RE: MESA DEL SOL MONTAGE UNIT 2, PORTRAIT PARK SWIMMING POOL
GRADING AND DRAINAGE PLAN - COA HYDRO FILE R16/D003B.
RESPONSE LETTER TO COMMENTS PROVIDED 3/14/2013

The purpose of this letter is to resubmit our grading and drainage plan for Portrait Park in response to the comments provided in your letter dated March 14, 2013. The following is an explanation concerning each comment.

C 101

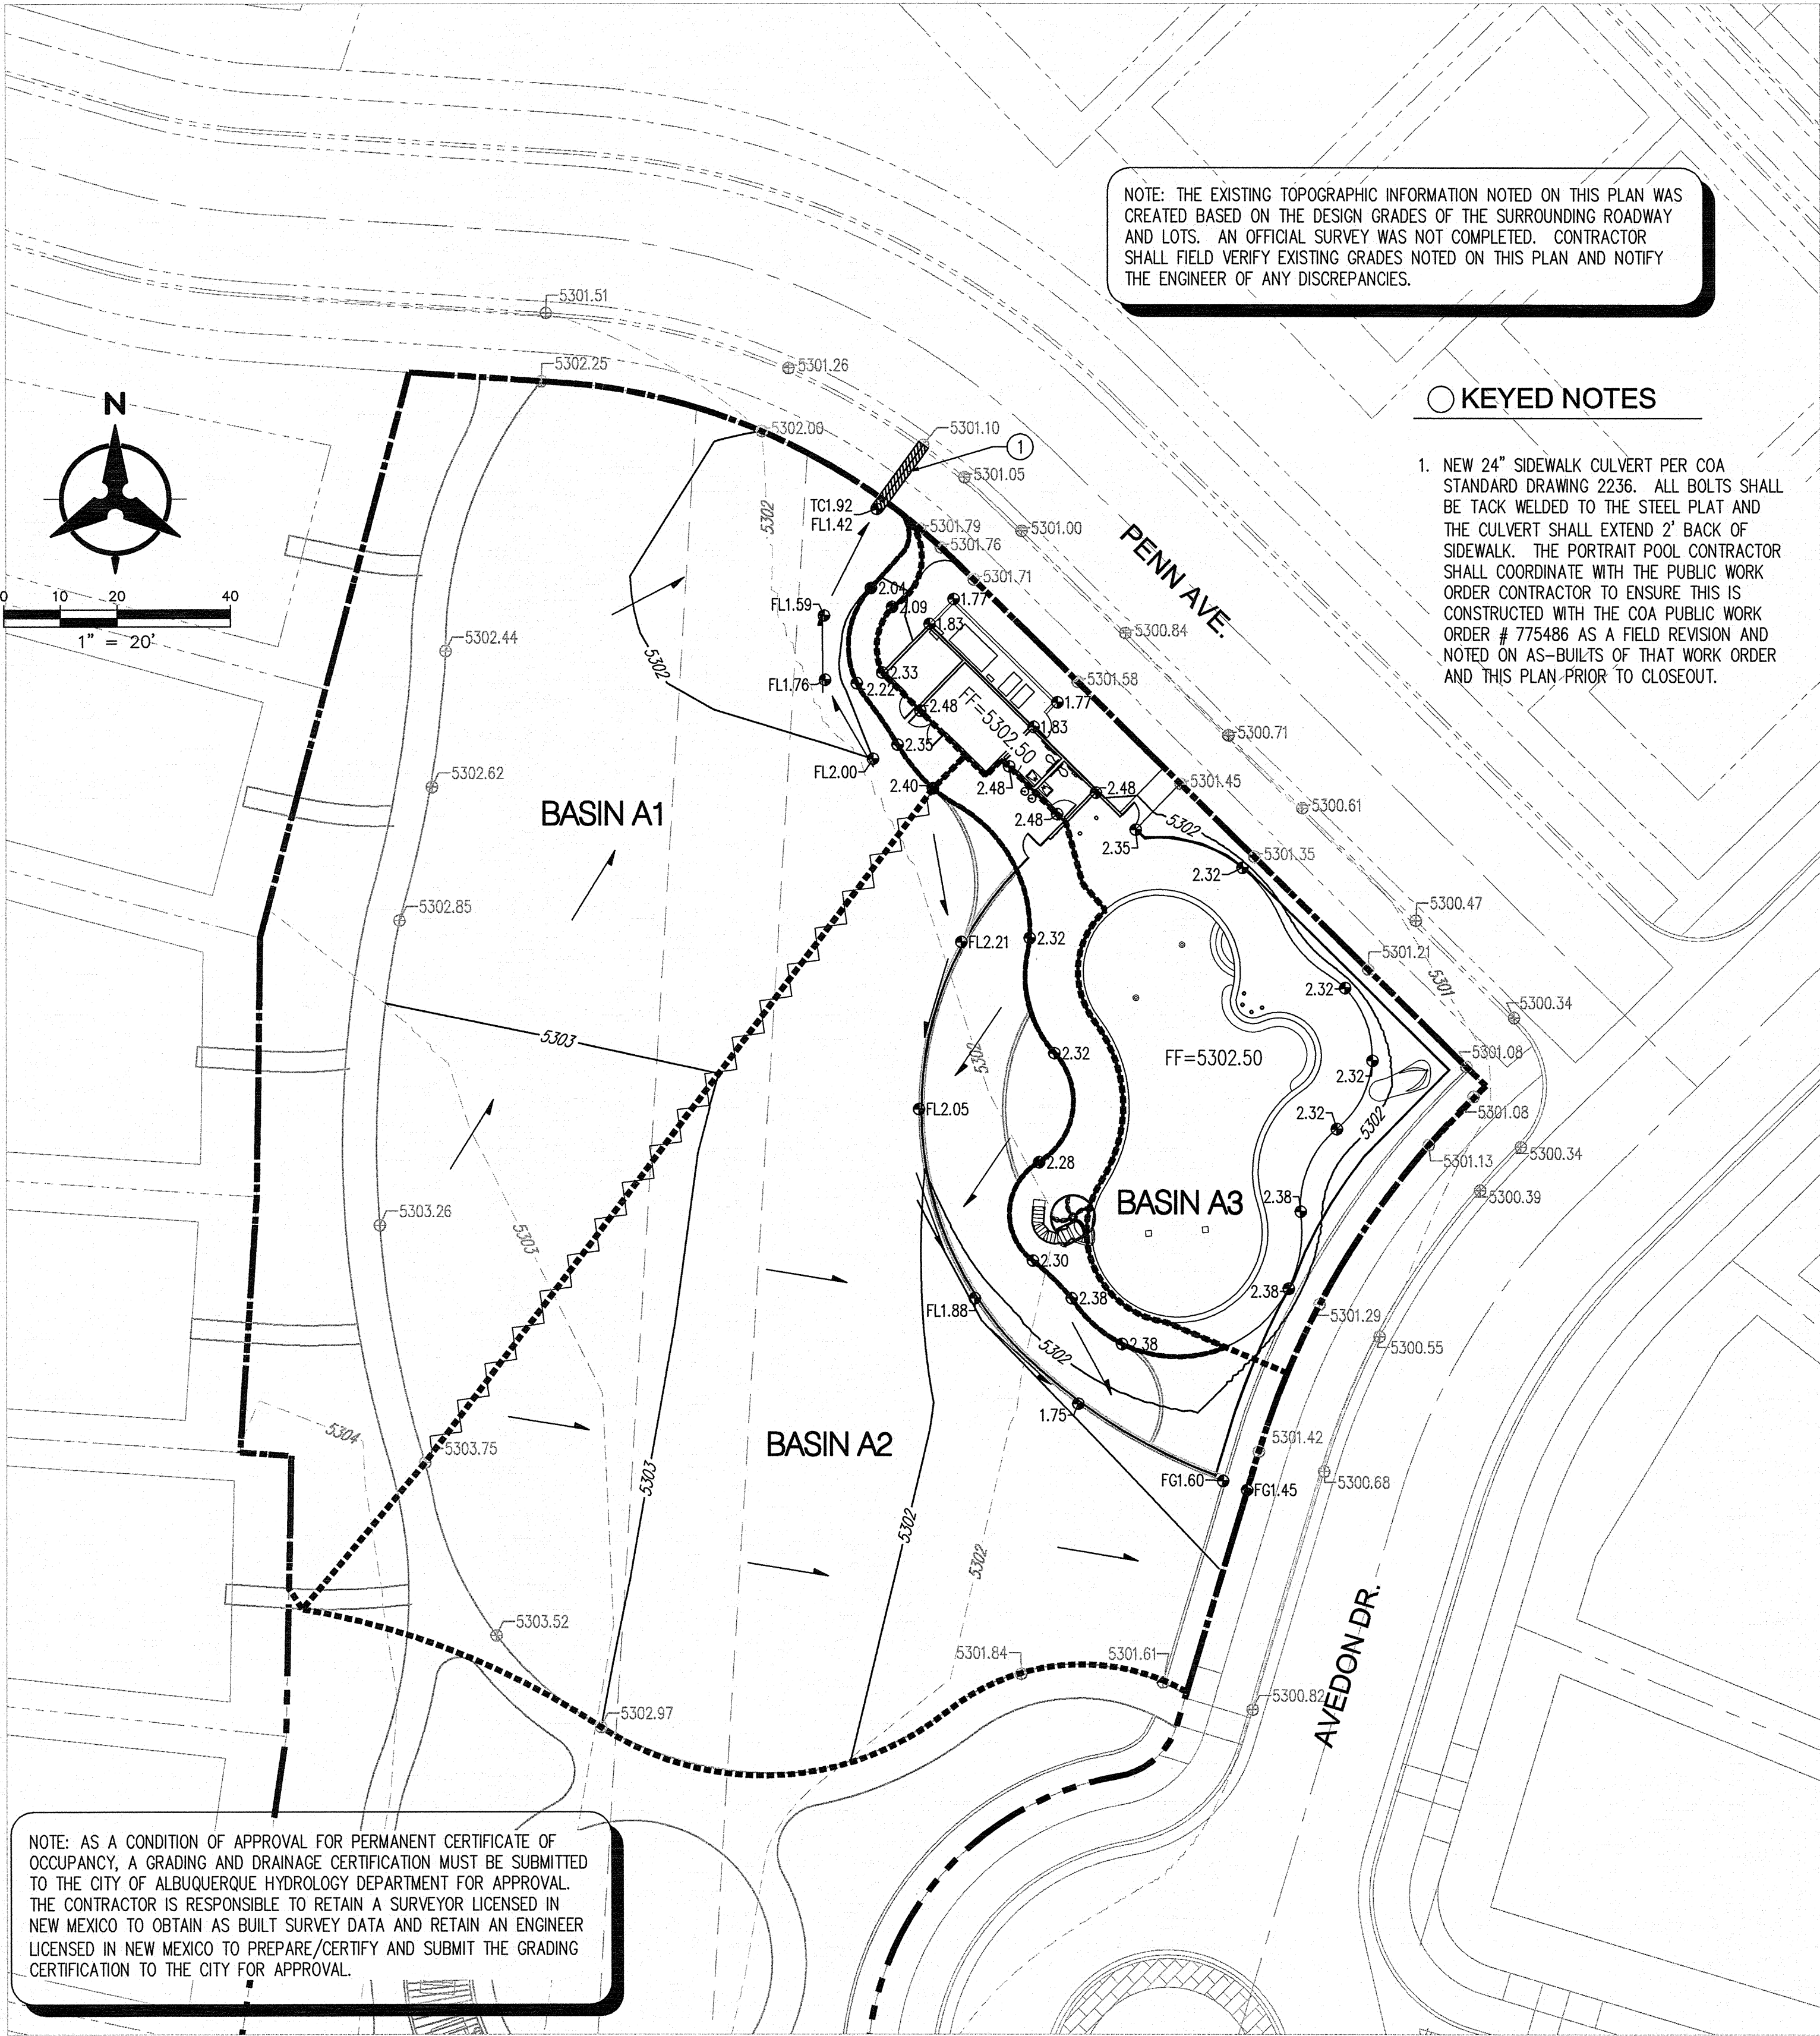
- The additional note has been added to the sheet.
- A 24" sidewalk culvert has been called out and has a sufficient capacity to handle Basin A1 which is less than 1.0 cfs.

- There is no paved parking or drive pads associated with this project. Basin A2 and A3 will discharge directly over the sidewalk along Avedon, Basin A2 the drainage from the pool enters the landscaped areas first prior to passing over sidewalk. See plan for developed basin calculations.

- No offsite flows are accepted from the southern portion of the site and that continues to drain as noted within the approved Unit 2 grading plan into Avedon.

- See the first response.
- Flowline elevations have been added to the adjoining streets.
